Local Policing Support Team

Our Ref: LM/ARU/20/26A

RE: 26 Burnham Avenue Bognor Regis PO21 2JU

Thank you for your correspondence of the 3rd September 2020, advising me of a planning application for Outline application with all matters reserved for 10 No. new dwellings consisting of 1 No. 1 bed property, 8 No. 2 bed properties & 1 No. 4 bed property with associated services, landscaping, car parking & amenity (resubmission following BR/49/19/OUT) at the above location, for which you seek advice from a crime prevention viewpoint.

SITE PLAN (PROPOSED) 1:200

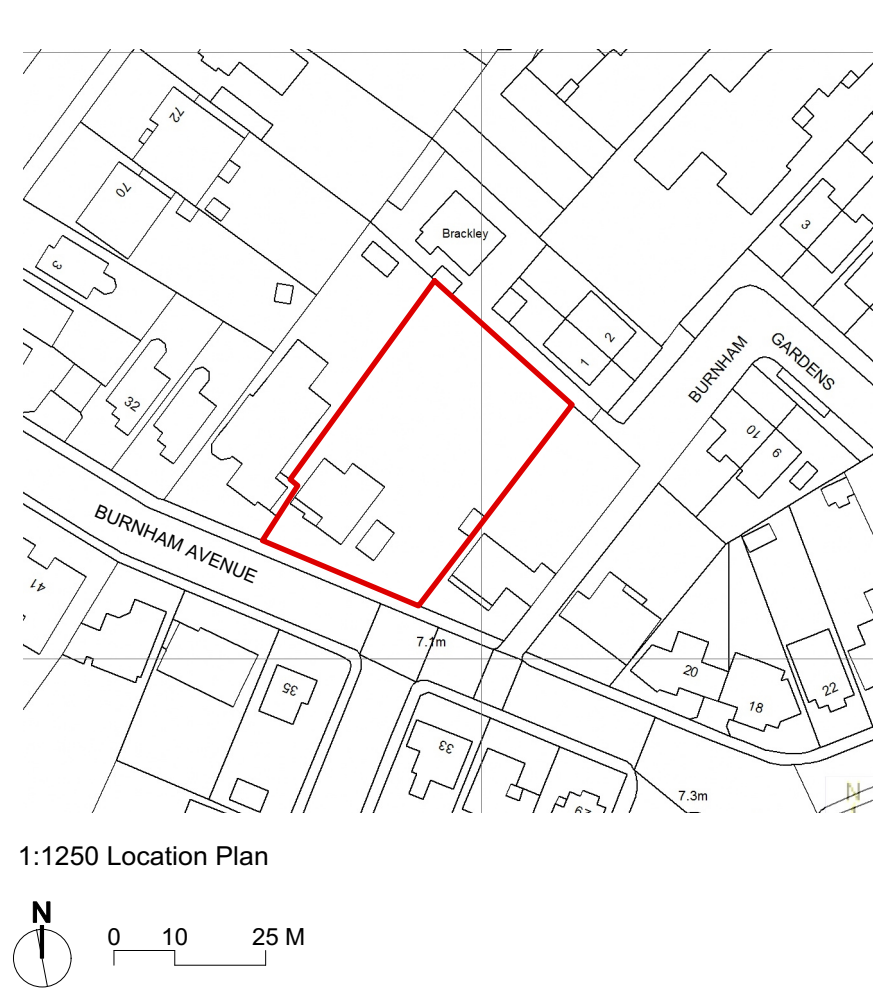
With regard to the proposed cycle storage refer the applicant to SBD Homes Version 2 2019 Chapter 56 56.3.

From a crime prevention perspective with regards to the 3 proposed gated entrances these need to be of a construction that allows natural surveillance to ensure the safety of users and do not aid unseen entry onto the site by a would be offender.

With regards to the proposed parking areas - where communal parking occurs it is important that they must be within view of an active room within the property. An active room is where there is direct and visual connection between the room and the street or the car parking area. Such visual connections can be expected from rooms such as kitchens and living rooms, but not from bedrooms and bathrooms. Gable ended windows can assist in providing observation over an otherwise unobserved area.
